COMMUNITY SERVICES DEPARTMENT

April 8, 2020

Subject: Creekside South at Lorson Ranch PUD (PUDSP201)

A TRACT OF LAND LOCATED IN THE NORTH HALF OF SECTION 23, T15S, R65W, OF THE 6th P.M.,
EL PASO COUNTY, COLORADO

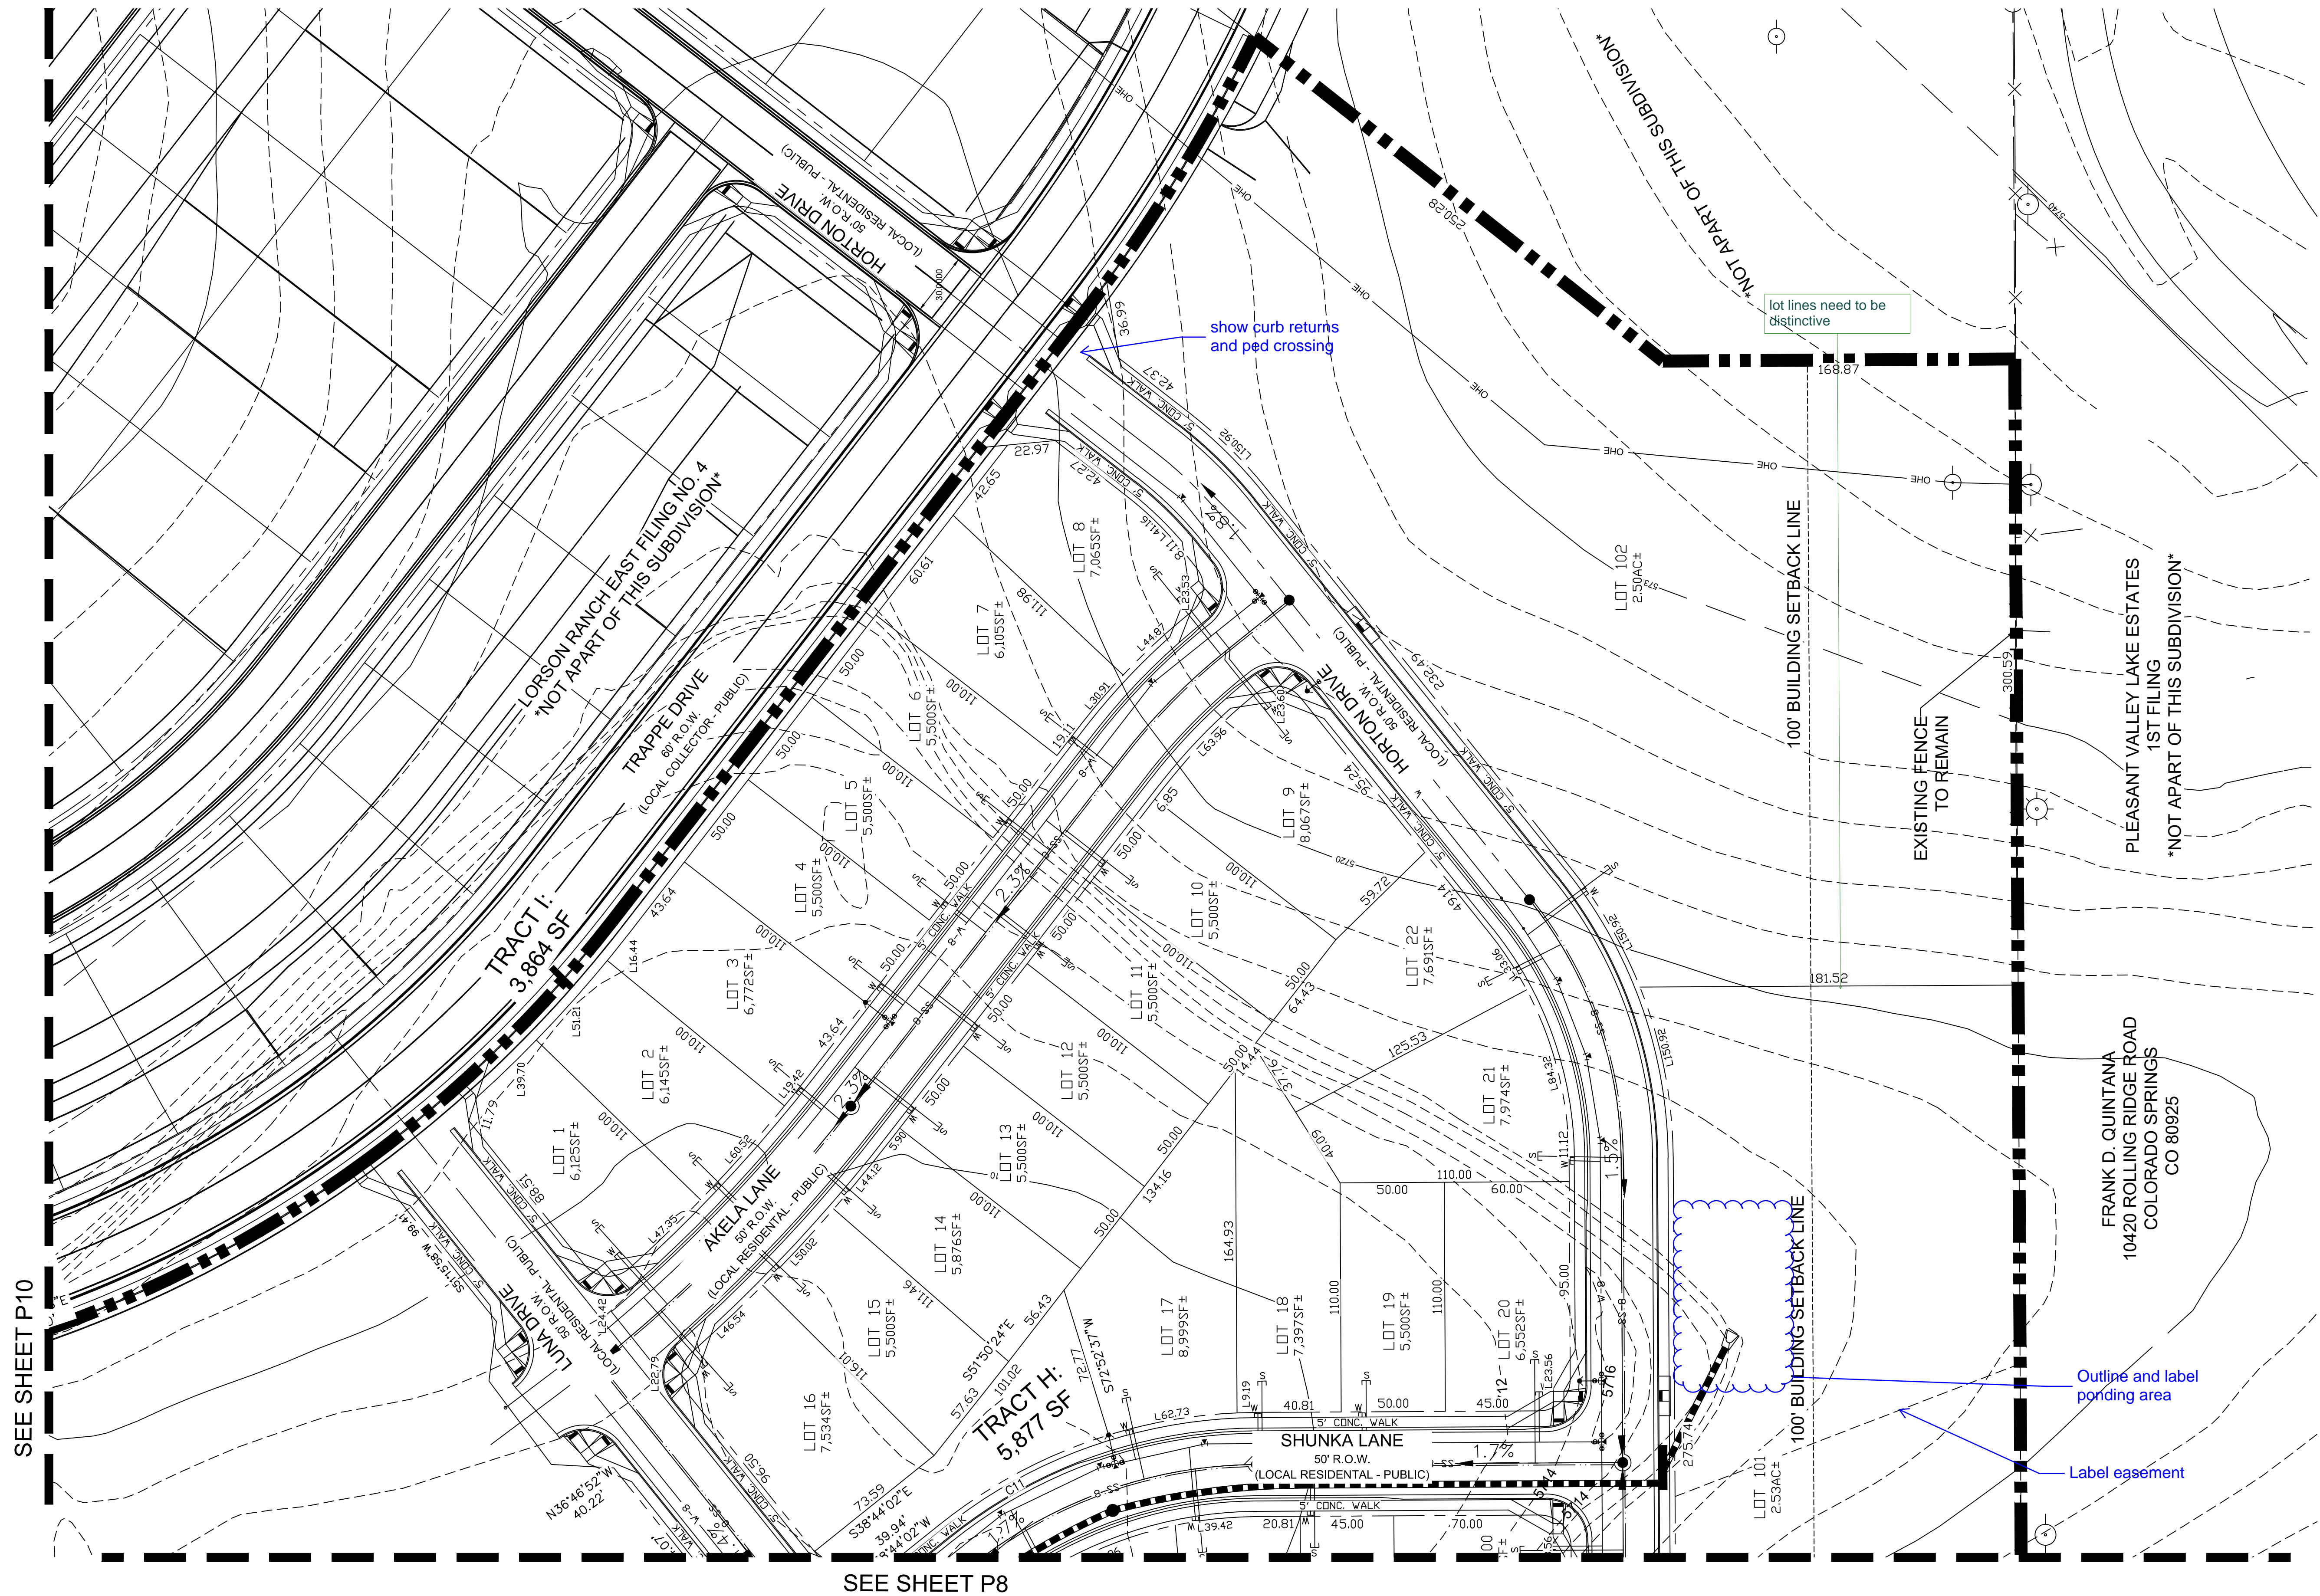
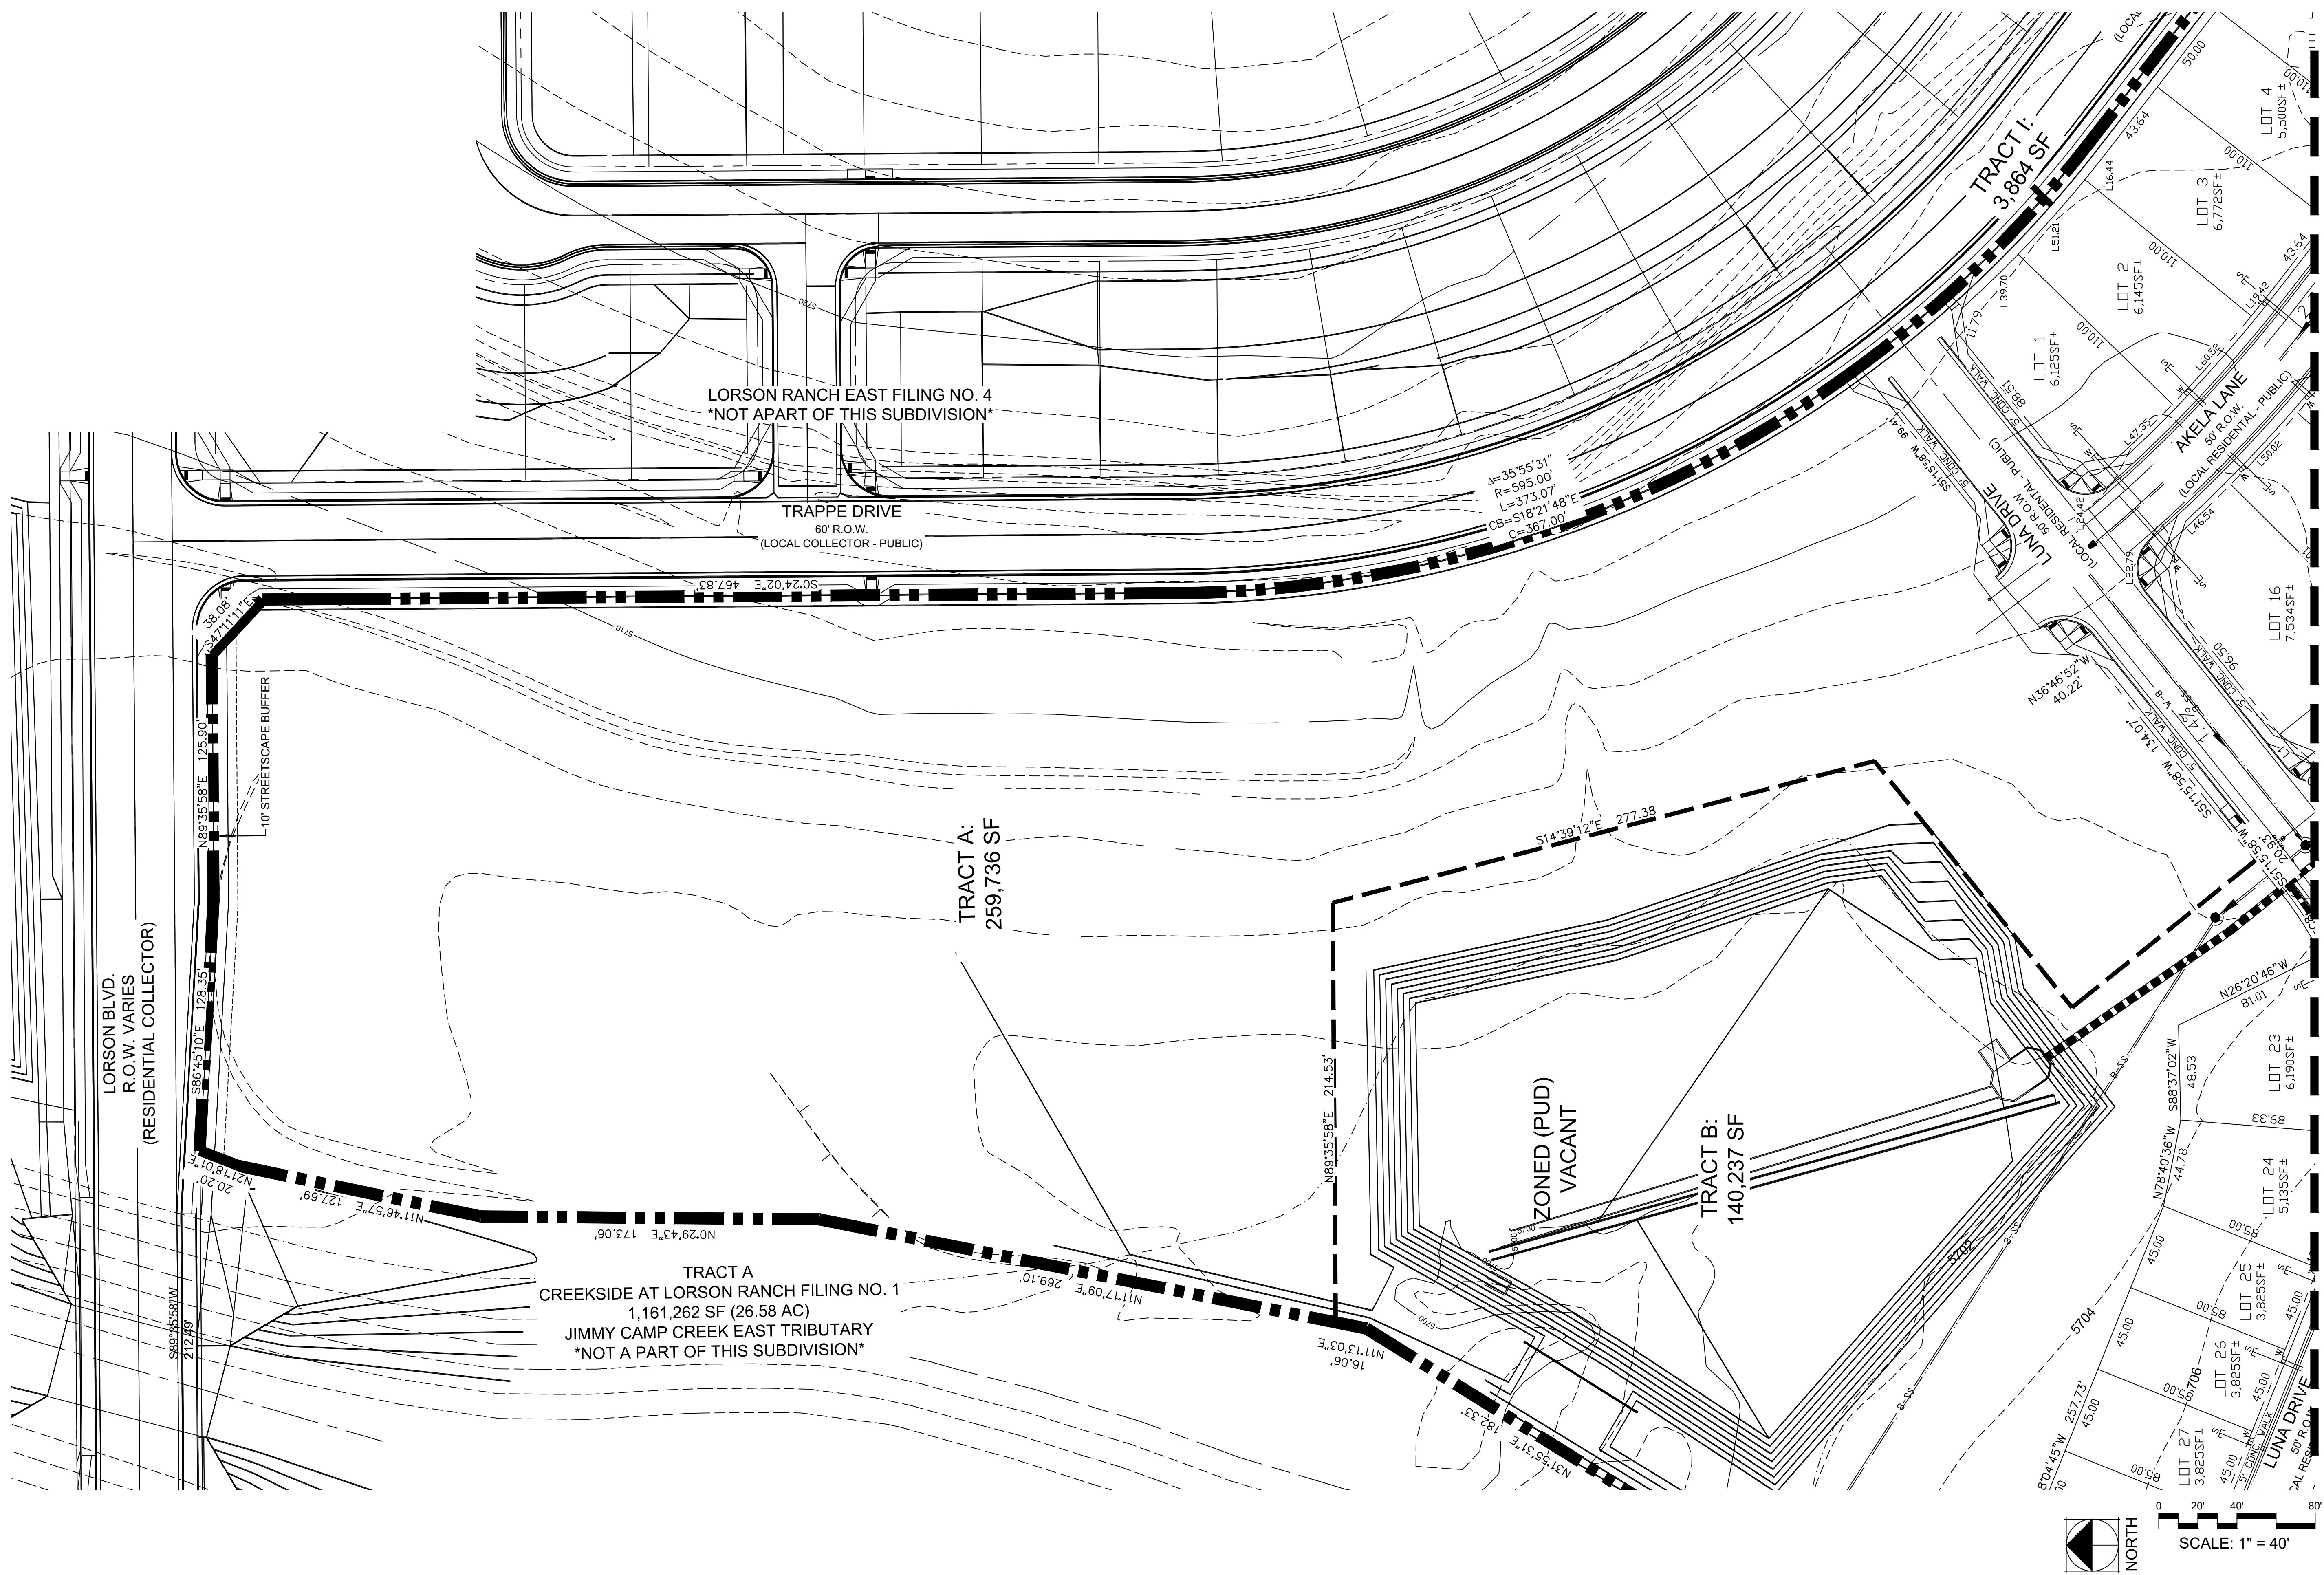
After a review of the Creekside South PUD plans staff notes there are no internal trails shown on the drawings. Staff strongly encourages the applicant provide a trail within the Creekside South PUD area and suggests the continuance of a trail that is shown on the previously approved Sketch Plan and within Lorson Ranch East Filing No. 4. This internal trail follows the overhead electric line corridor, crosses Trappe Drive, and is shown ending within Creekside South at the southern boundary of Lorson Ranch. Staff recommends the applicant continue this trail west through the buffer space adjacent to Horton Drive to provide a trail connection to Creekside South.

Recommend to the Planning Commission and Board of County Commissioners that approval of Creekside South at Lorson Ranch Planned Unit Development include the following conditions: (1) recommend the applicant include a non-County internal trail along the southern site boundary; (2) required fees for regional park purposes total \$93,400 and urban park purposes total \$59,000. However, these fees will be calculated upon review of forthcoming final plats. A park lands agreement may be an acceptable alternative to urban park fees provided the agreement is approved by the County and executed prior to recording the forthcoming final plats.
